CITY OF ALBUQUERQUE

Re: Ram RV
8100 Jacs Lane NE
30-Day Temporary Certificate of Occupancy
Transportation Development Final Inspection
Architect's Stamp dated 4-23-20 (D16-D002A8)
Certification dated 02-24-22

SHEET NUMBER
 AS-1.0

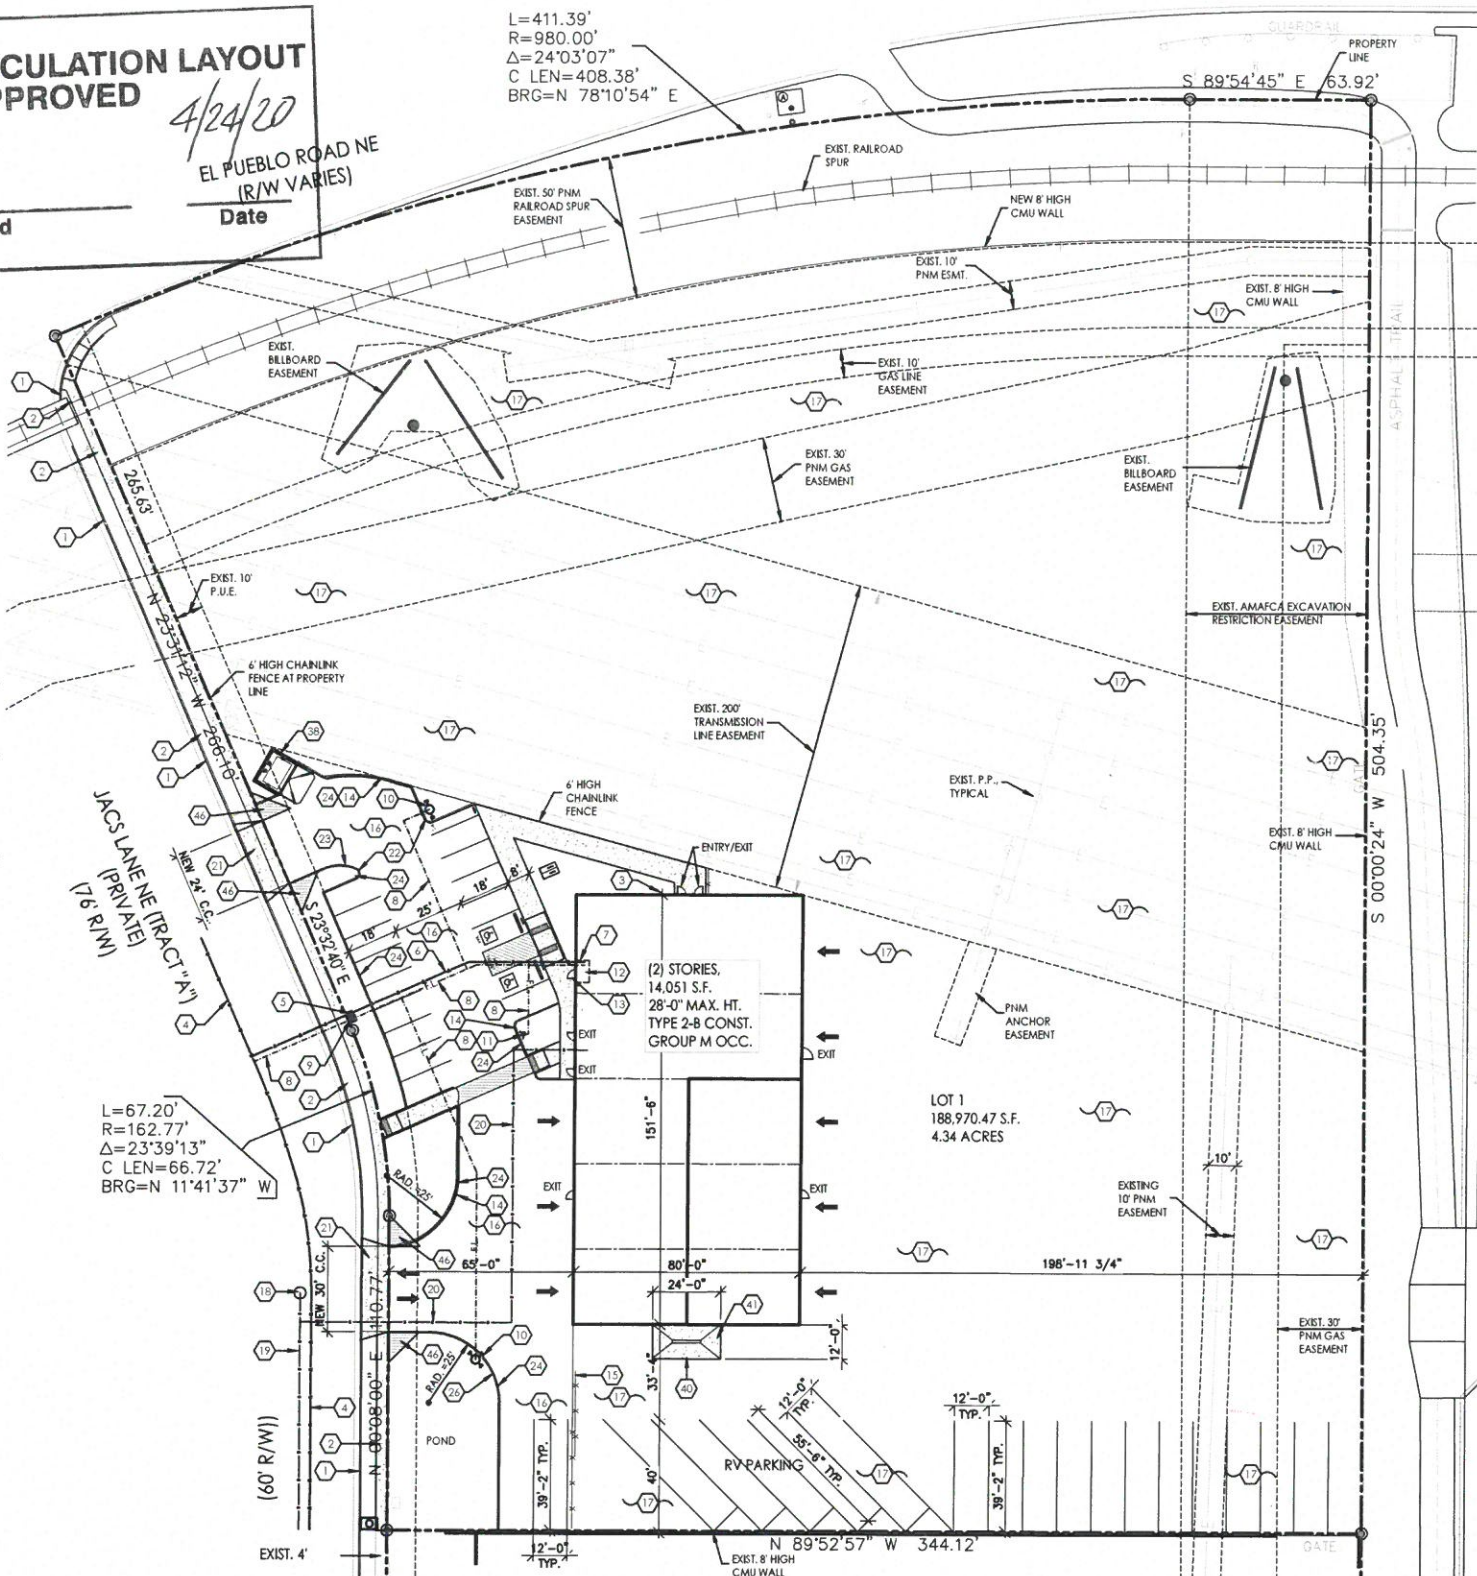
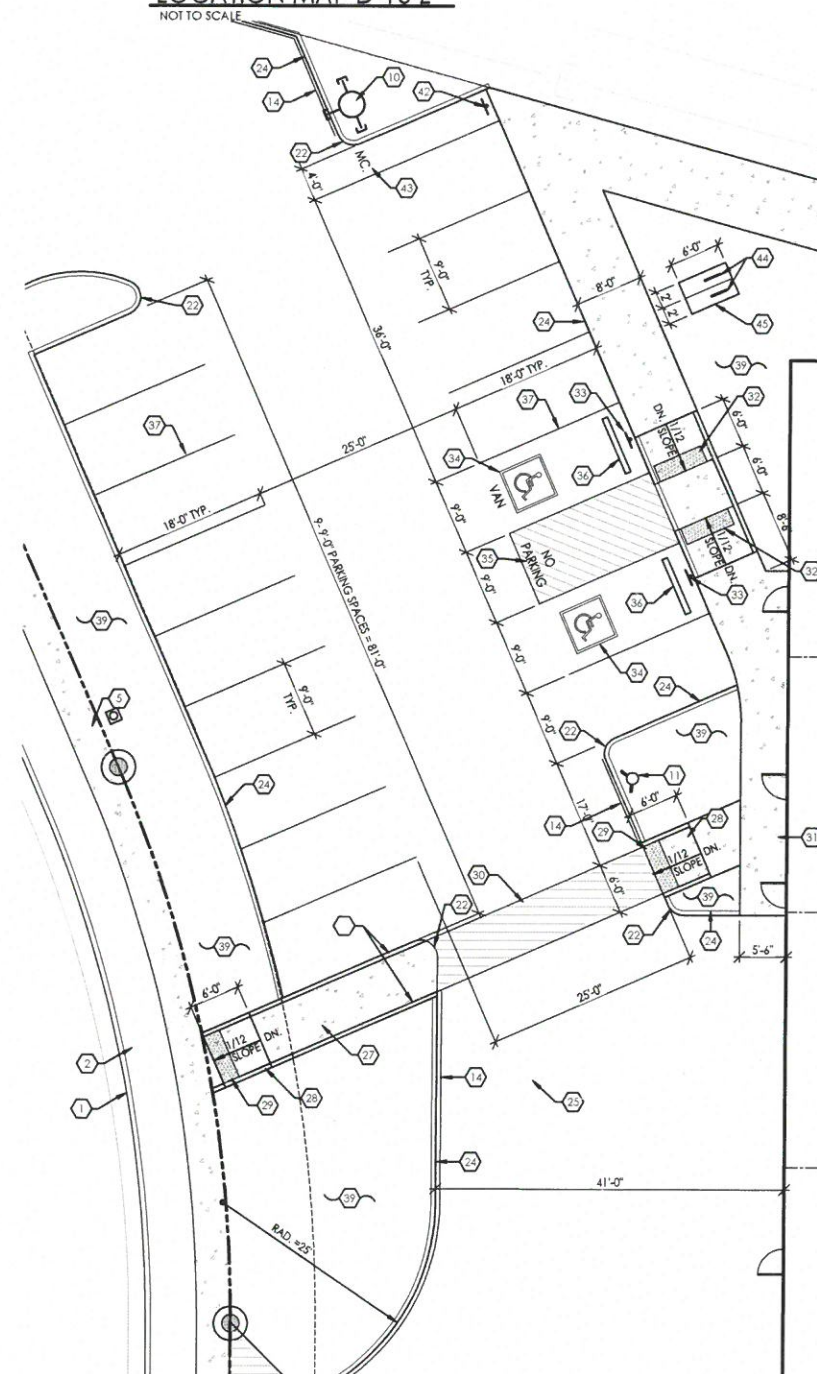
- The ADA access aisles shall have the words "**NO PARKING**" in capital letters, each of which shall be at least one foot high and at least two inches wide, placed at the rear of the parking space so as to be close to where an adjacent vehicle's rear tire would be placed. (66-1-4.1.B NMSA 1978)
- Provide Motorcycle Parking Sign, either free-standing or wall mounted per the zoning code.
- Please explain why the RV parking area has not been developed yet?

Once these corrections are complete, email pictures & redlined TCL plan showing the changes to PLNDRS@cabq.gov, and malnajira@cabq.gov for release of Final CO.
